**REQUEST**

Current Zoning: N1-C (neighborhood 1-C).  
 Proposed Zoning: N2-A(CD) (neighborhood 2-A, conditional)

Approximately 4.09 acres located along the north side of Hovis Road, west of Wildwood Avenue.

The petition proposes the development of up to 39 multi-family attached dwelling units. The site is currently undeveloped.

SHEET NUMBER
RZ-2

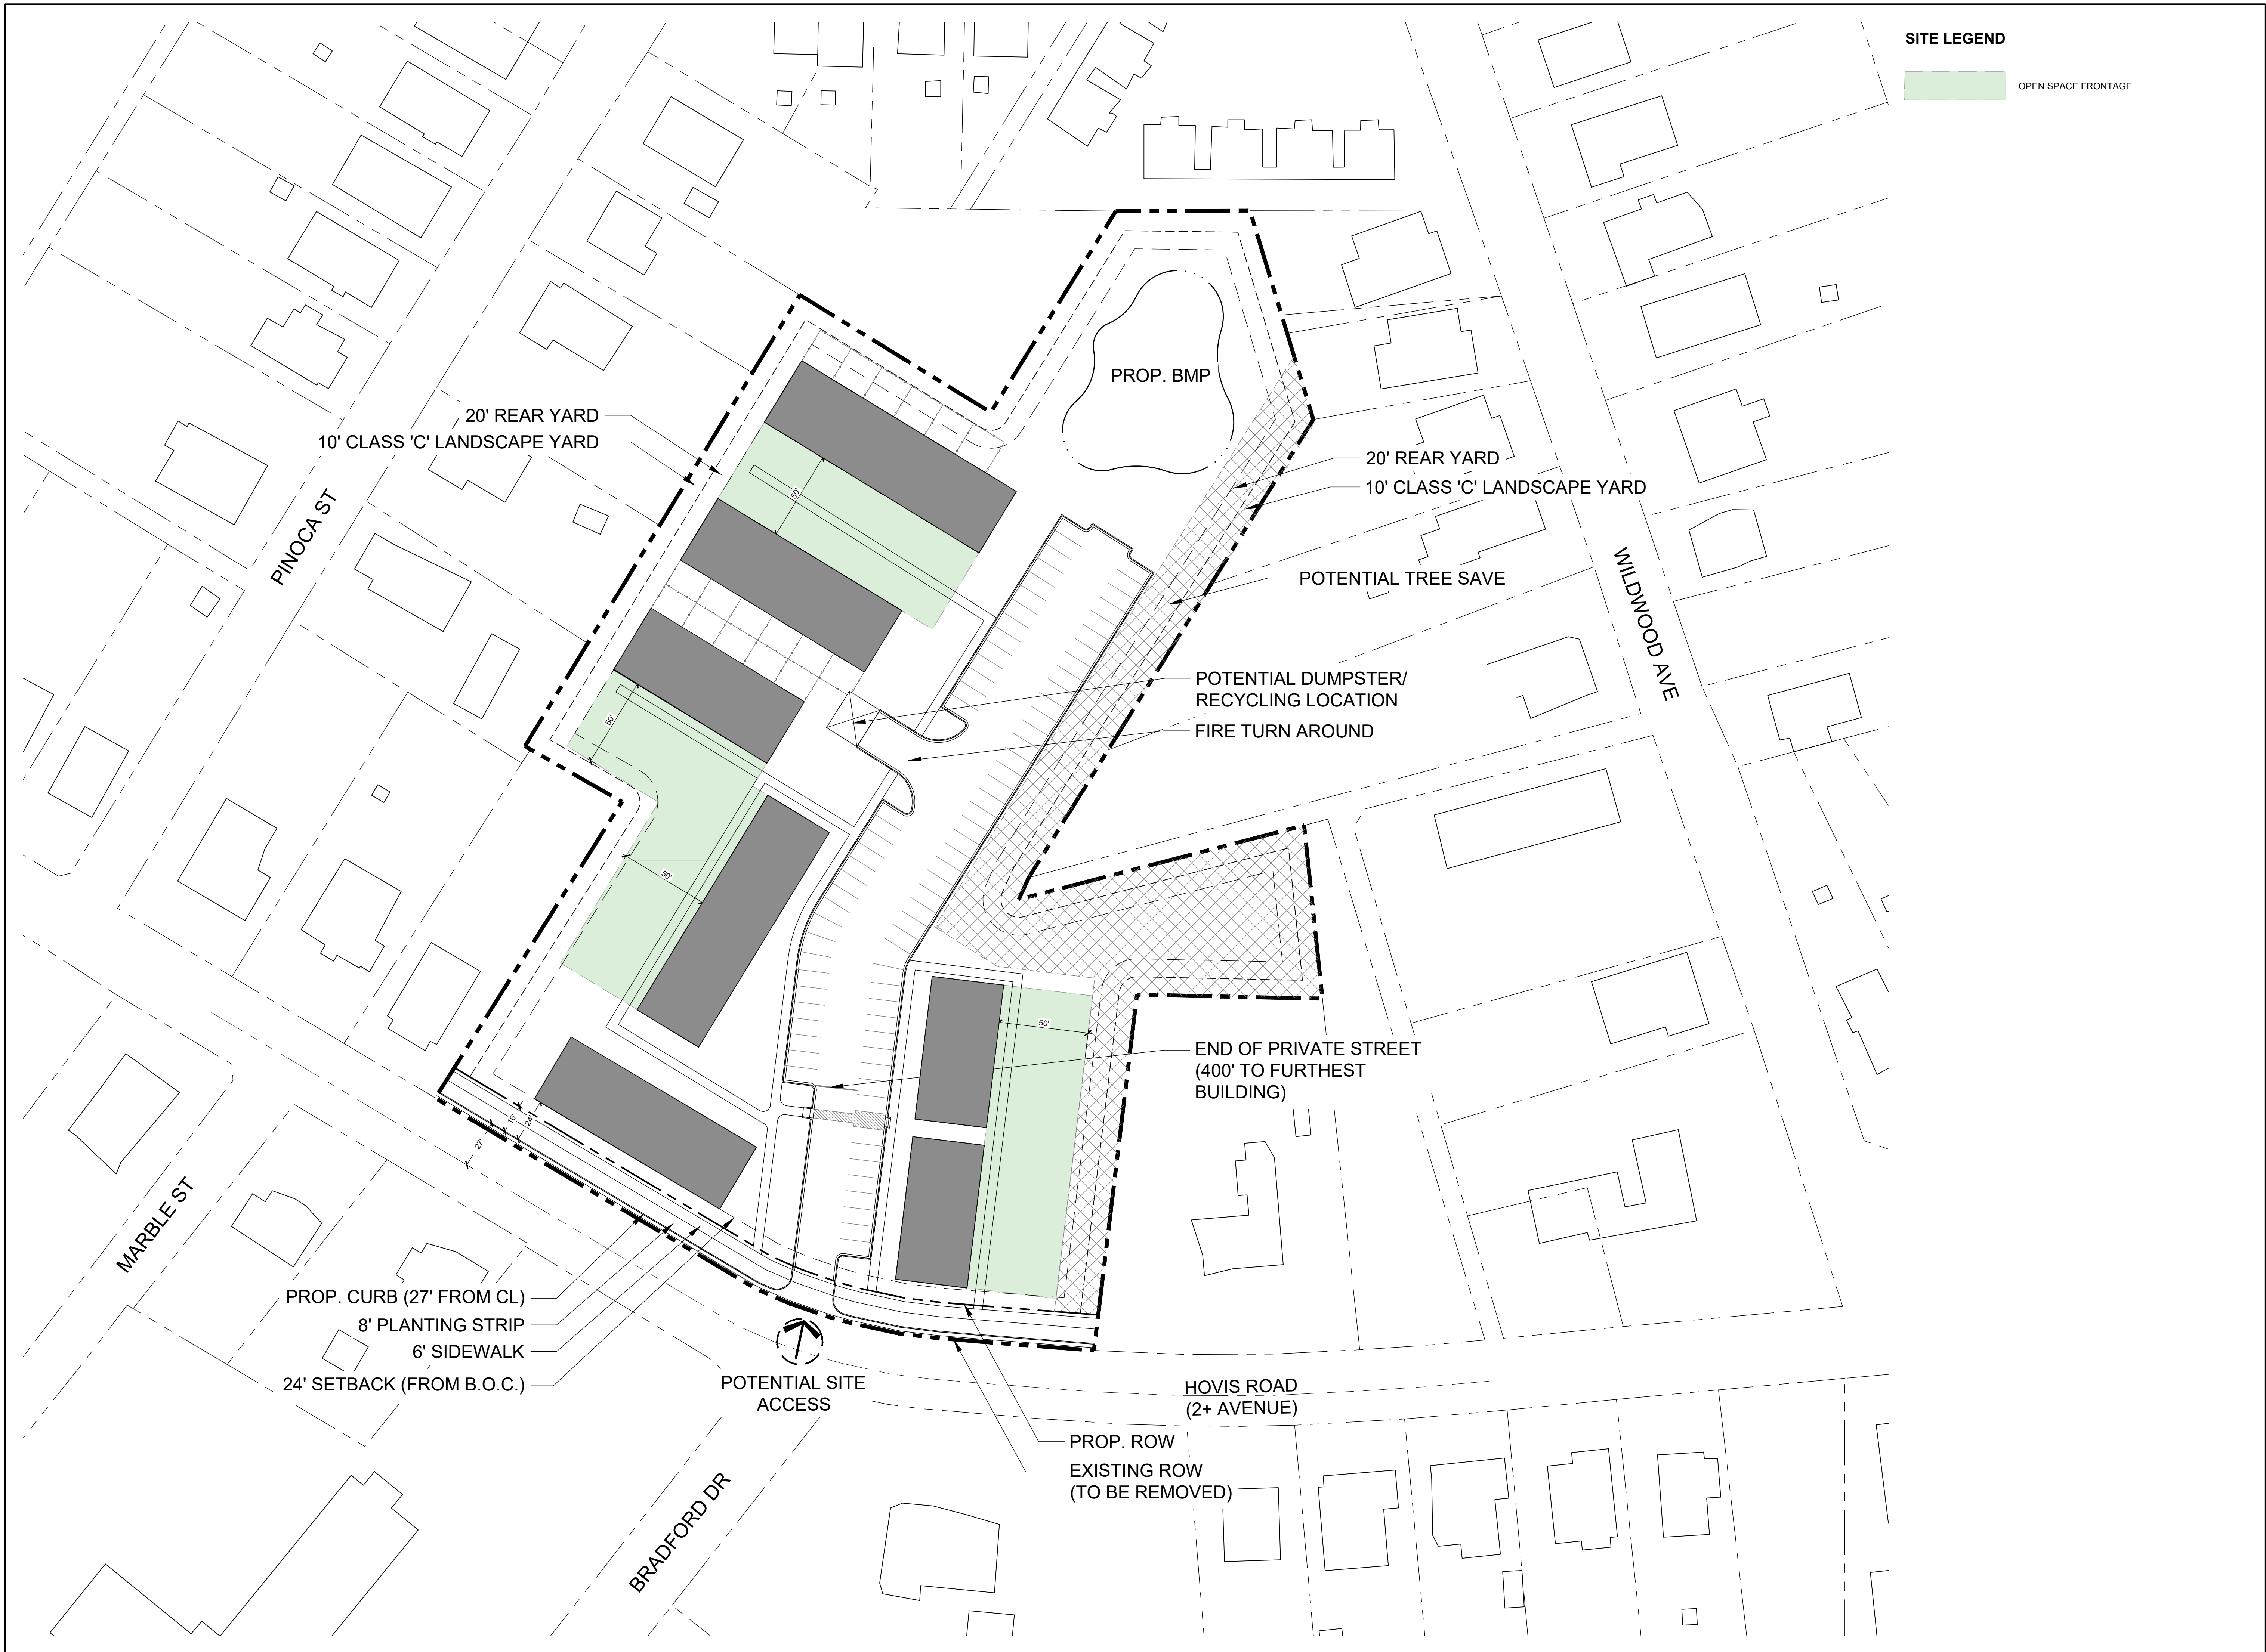
1. ~~Urban Forestry: No trees are located in designated tree save/green area shown on site plan.~~  
**Addressed**

2. ~~Housing and Neighborhood Services: under General Provision 3.a the proposed text "House CLT" should be amended to "House Charlotte Program."~~ **Addressed**
  3. ~~Entitlement Services: the large central parking area does not match the character of the neighborhood. The parking lot should be reconfigured to breakdown the scale of the parking.~~  
**Addressed**
  4. ~~Entitlement Services: the height of buildings abutting properties in the Neighborhood 1 Place Type should be reduced to 40 feet.~~ **Addressed**
-
